Parkes Hospital Redevelopment – Exhibition of EIS [SSD-6107][Our Ref: ER22862]

The NSW Office of Water has reviewed the Environmental Impact Statement for the proposed Parkes Hospital Redevelopment modification. The following comments and recommended condition of approval are provided to assist in finalising the assessment of the project.

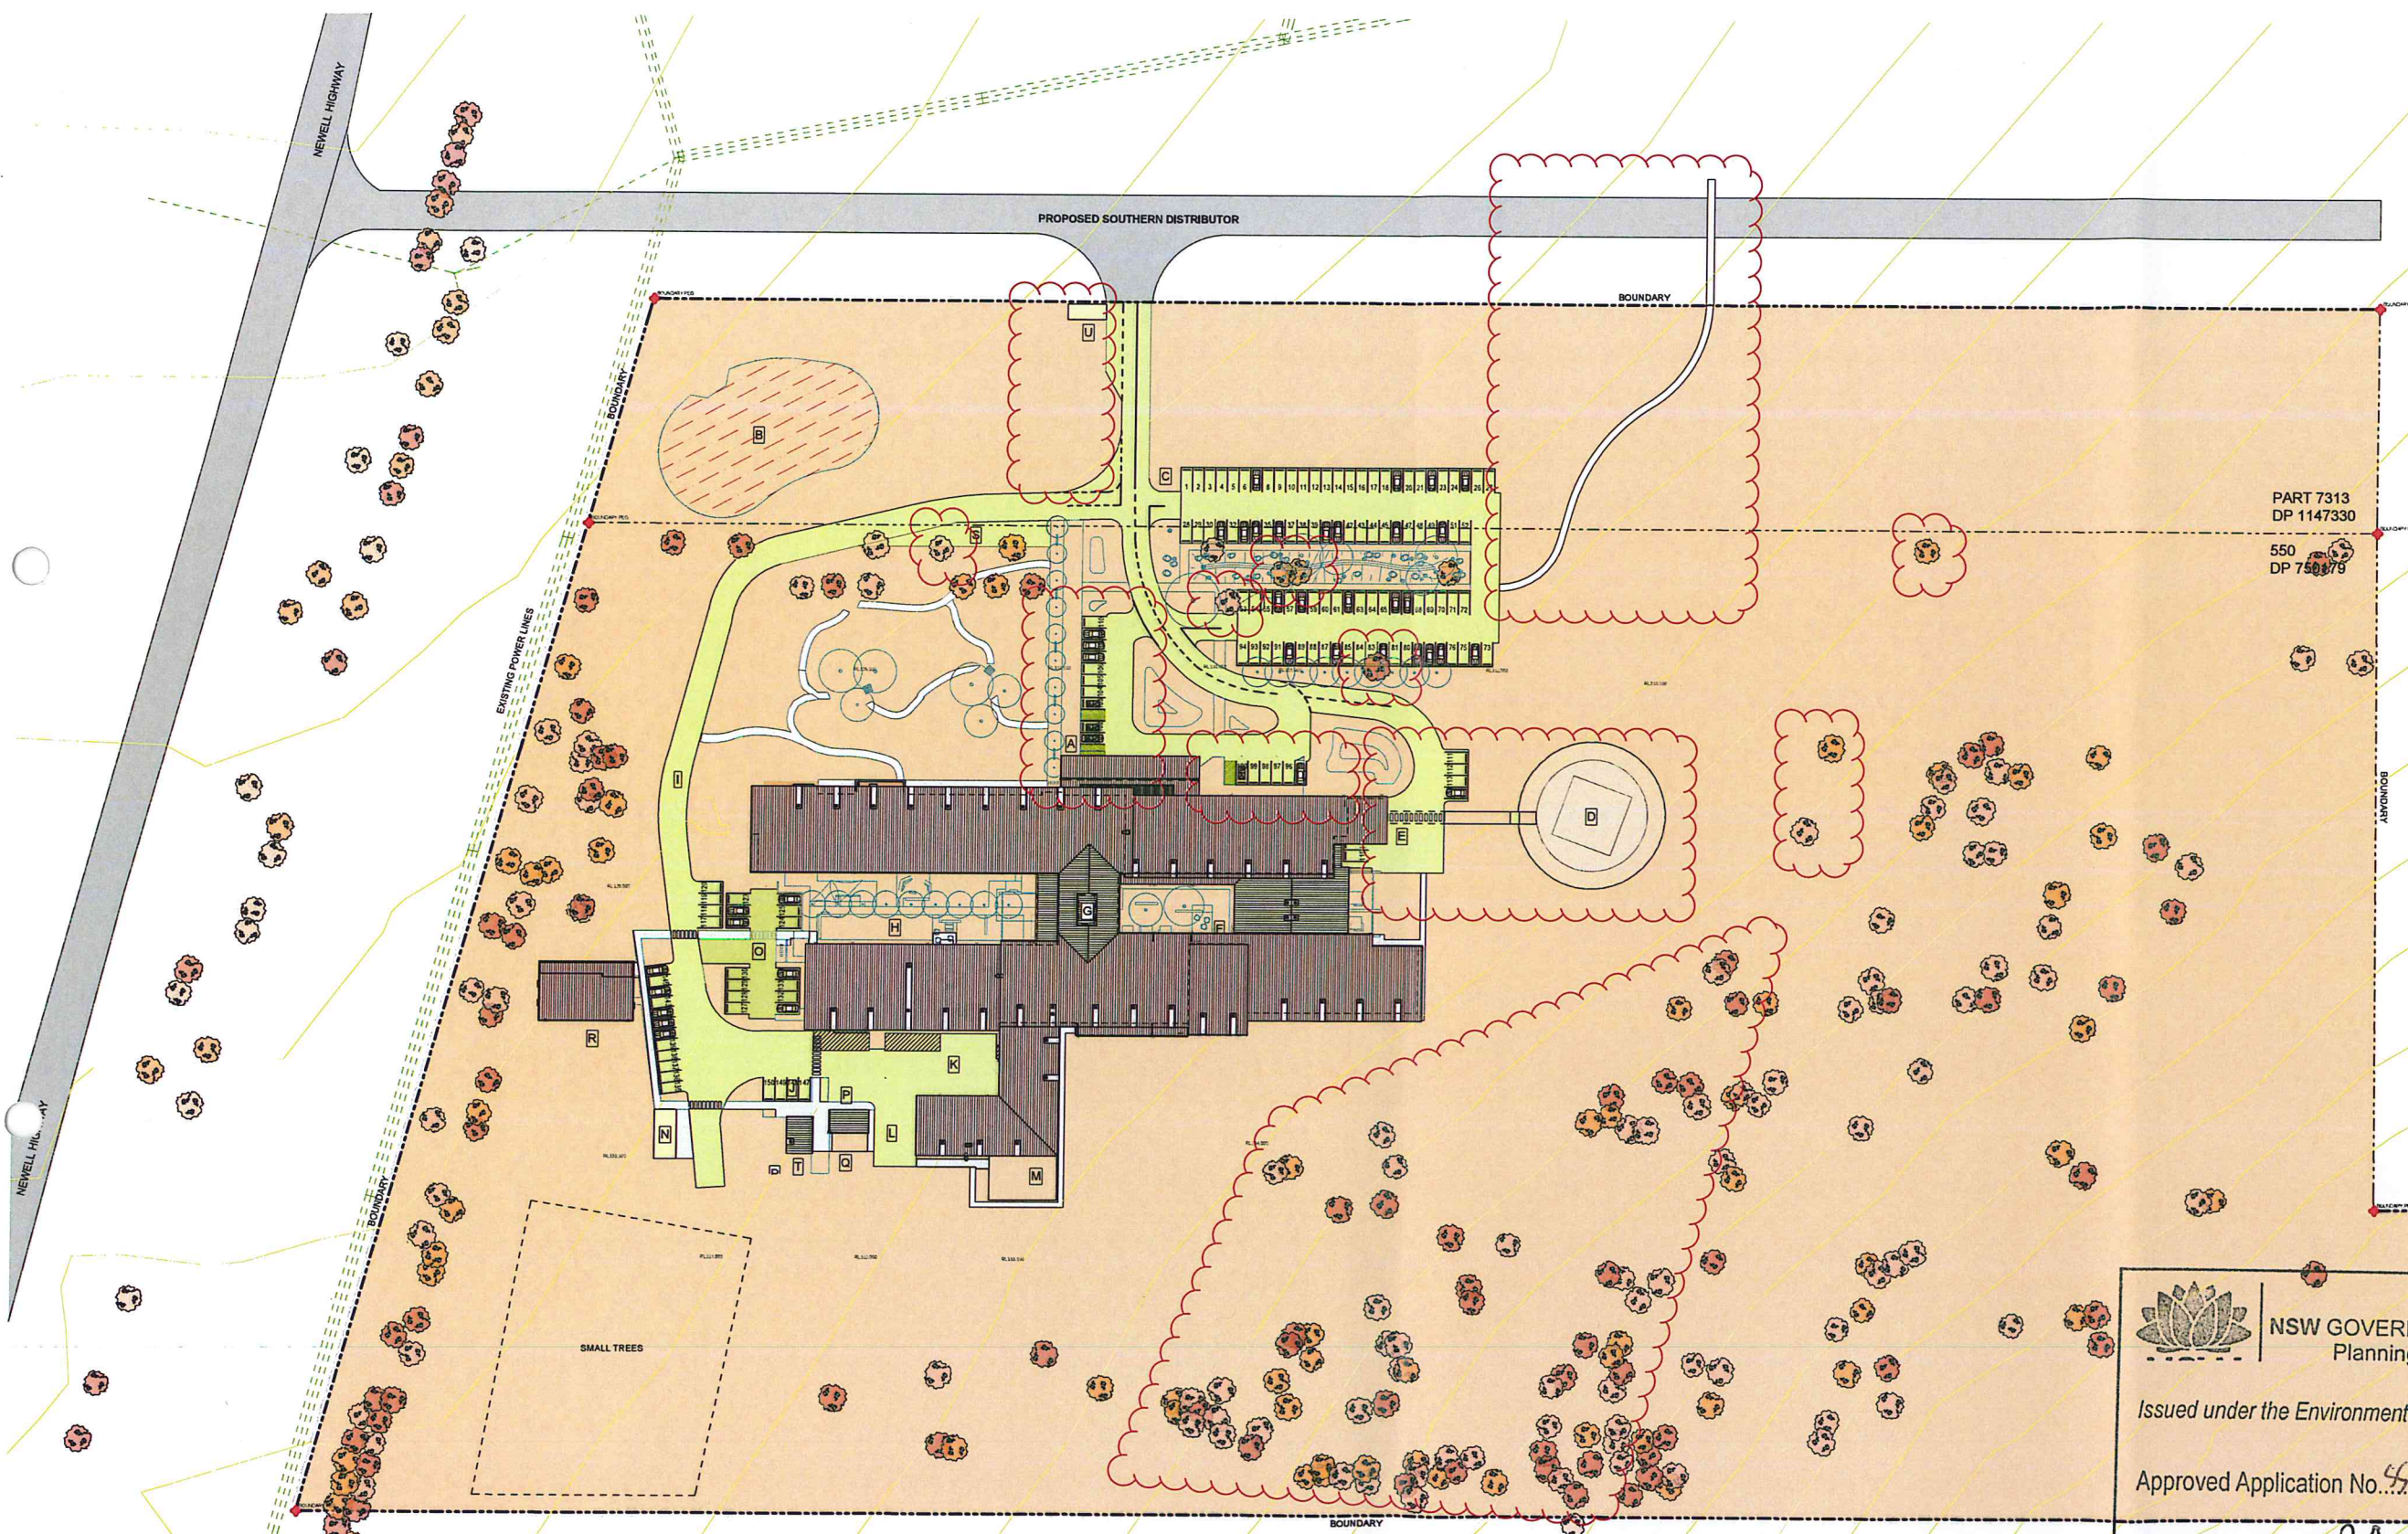
- Section 2.2 of the Civil and Structural Report (Appendix O) refers to a proposed stormwater detention pond in the north-west of the site. Further detail is requested to confirm whether this pond is to be designed to drain completely following a rain event or whether there is the intention to retain water. If water is to be retained within the pond, this will need to be considered within the Maximum Harvestable Rights Dam Capacity (MHRDC) for the property. Further detail on MHRDC can be accessed at the following link: <http://www.water.nsw.gov.au/Water-Licensing/Basic-water-rights/Harvesting-runoff/default.aspx>
